Comments by Winchester City Council on Draft Development Consent Order for consideration at the ISH1 on 9 December 2020

The current public version of the dDCO is the one submitted by the applicant at deadline 3. The following comments are based on that document and on those submitted by the Council at deadline 4. They have been refined to reflect further consideration of the contents by the Council.

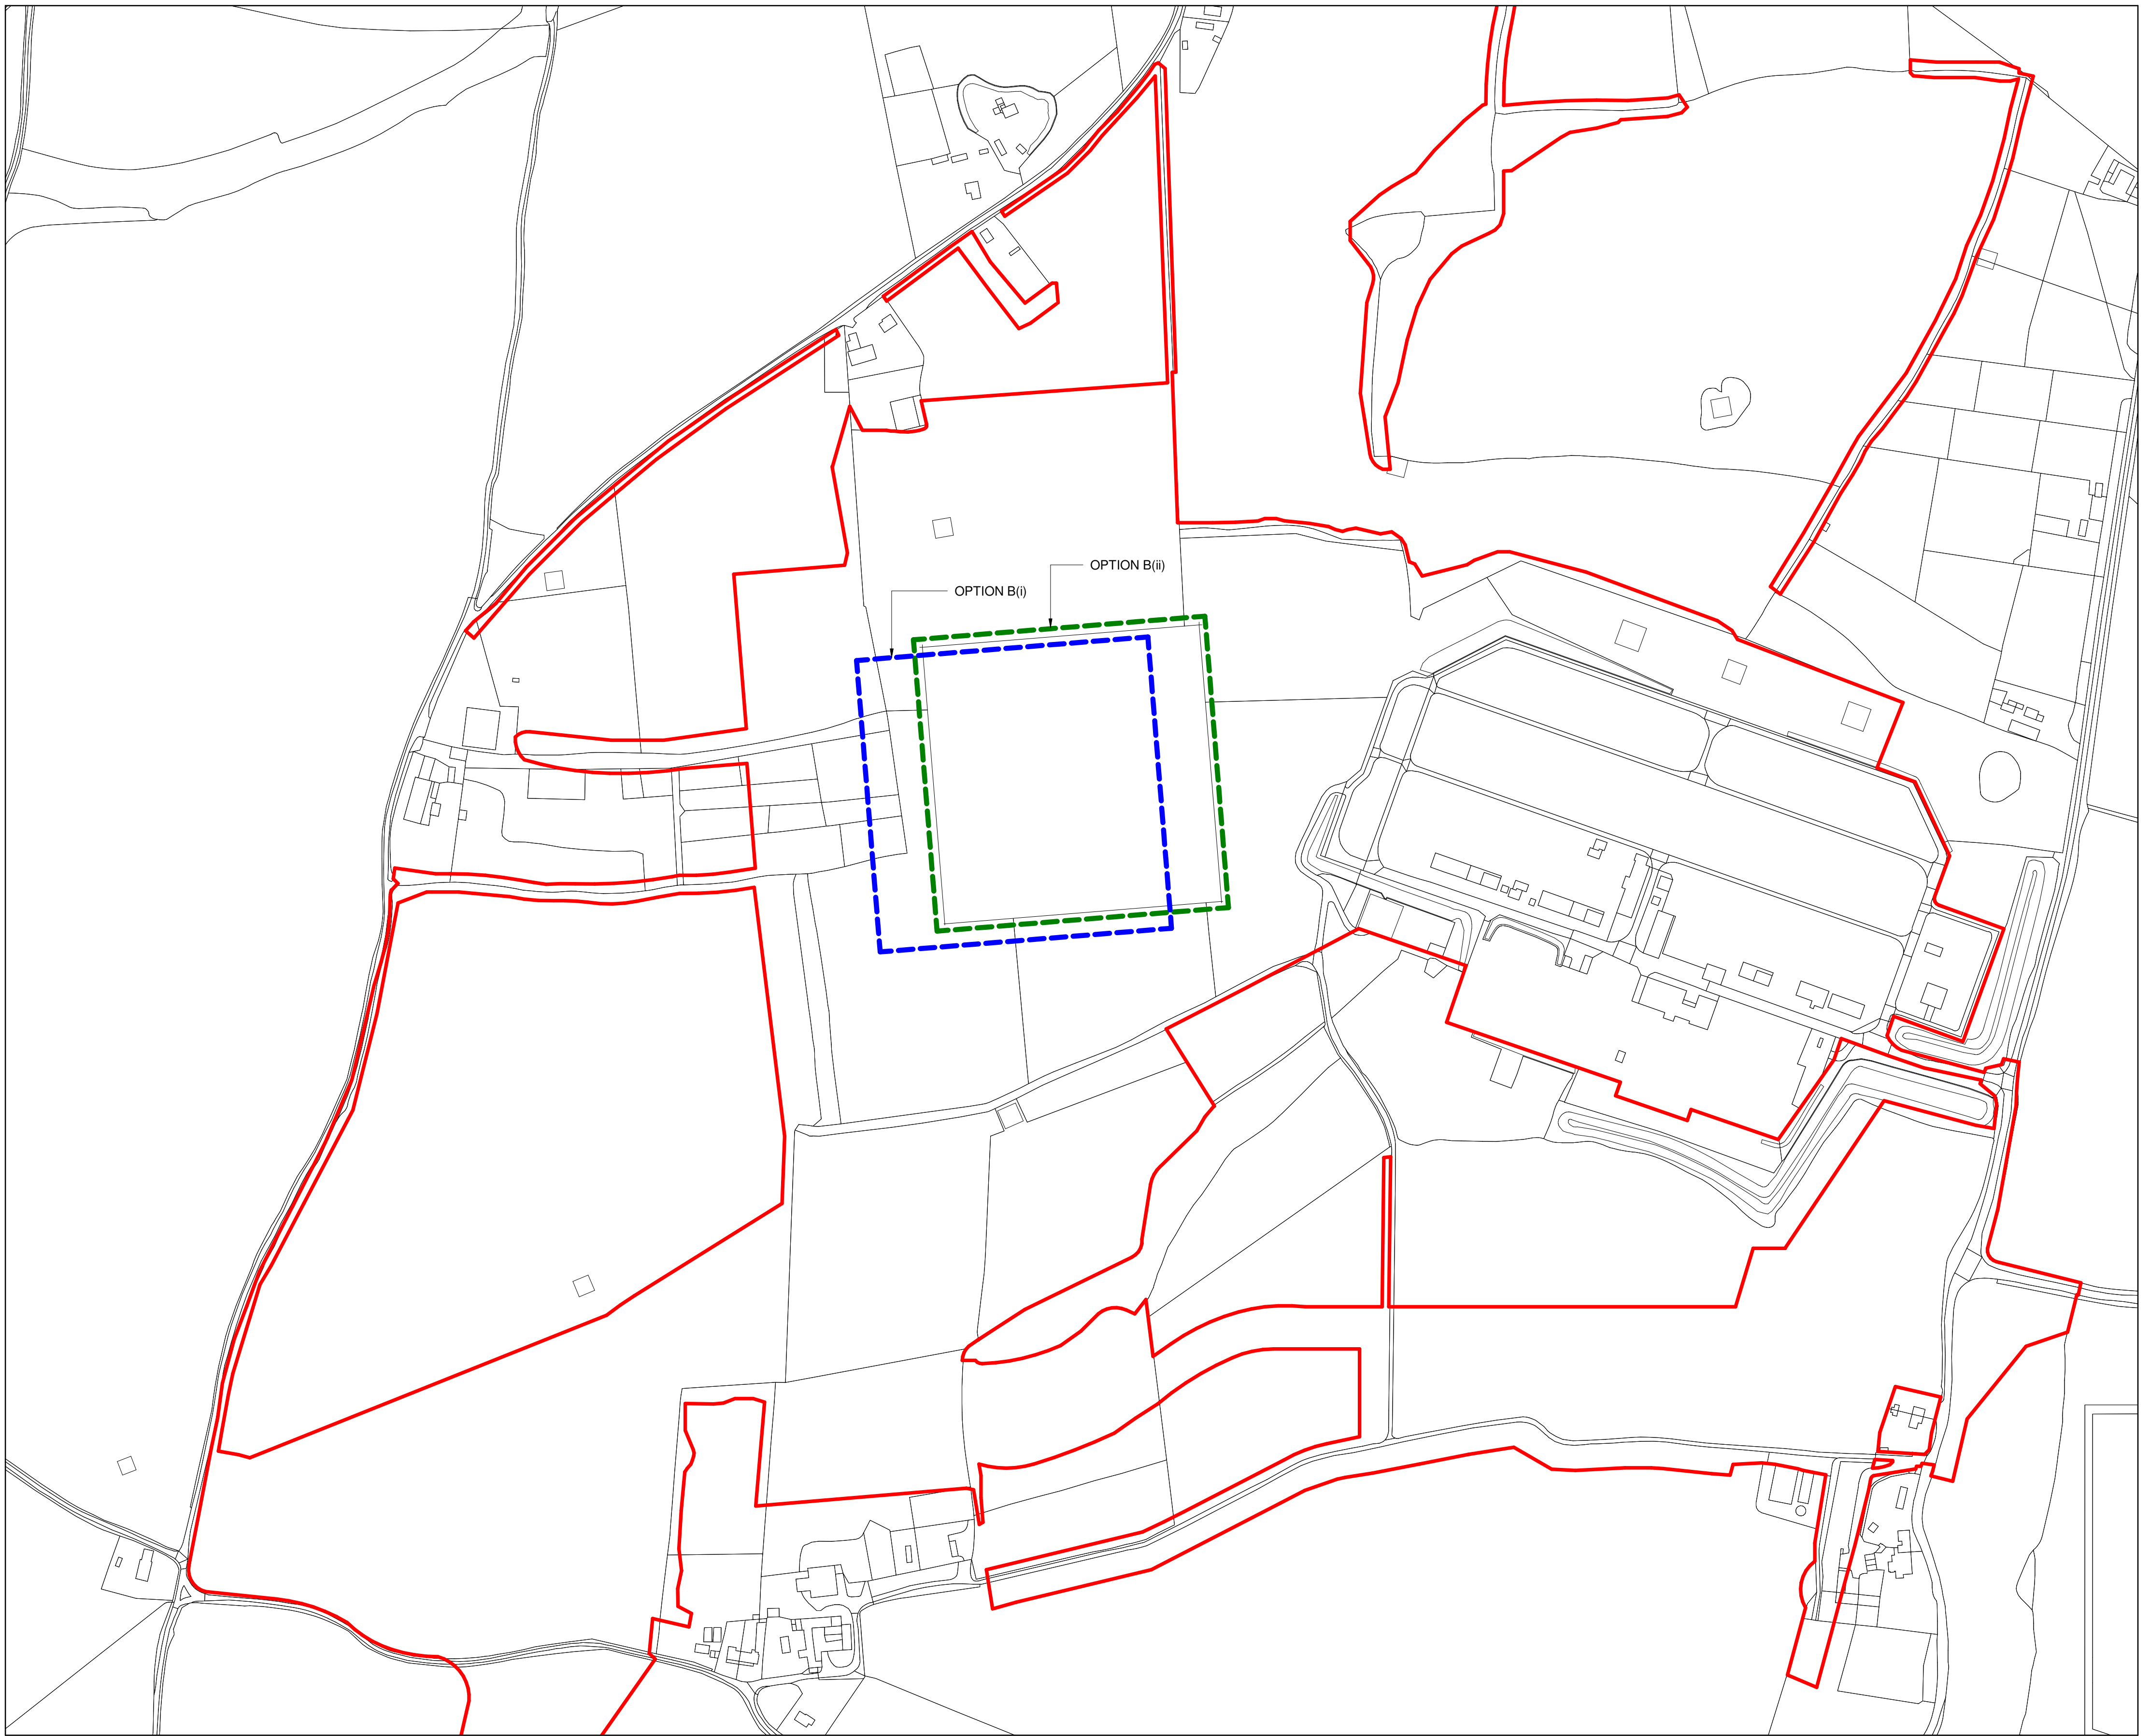
Prior to the commencement of any works within Work No.2 where the converter station is to be located the undertaker will confirm to the relevant planning authority which converter station perimeter option shown on the Converter Station Parameter Plan with reference EN020022-2.6-PARA-Sheet1 listed in Schedule 7 to the Order the converter station will be constructed within.

In Table WN2, the Lightning mast height is given as 30m. Understood there are also some on top of the building at 4m tall. It needs to say that the 30m masts are positioned in the yard area.

The maximum overall height of the Converter Station of 111.1m AOD should be in here somewhere.
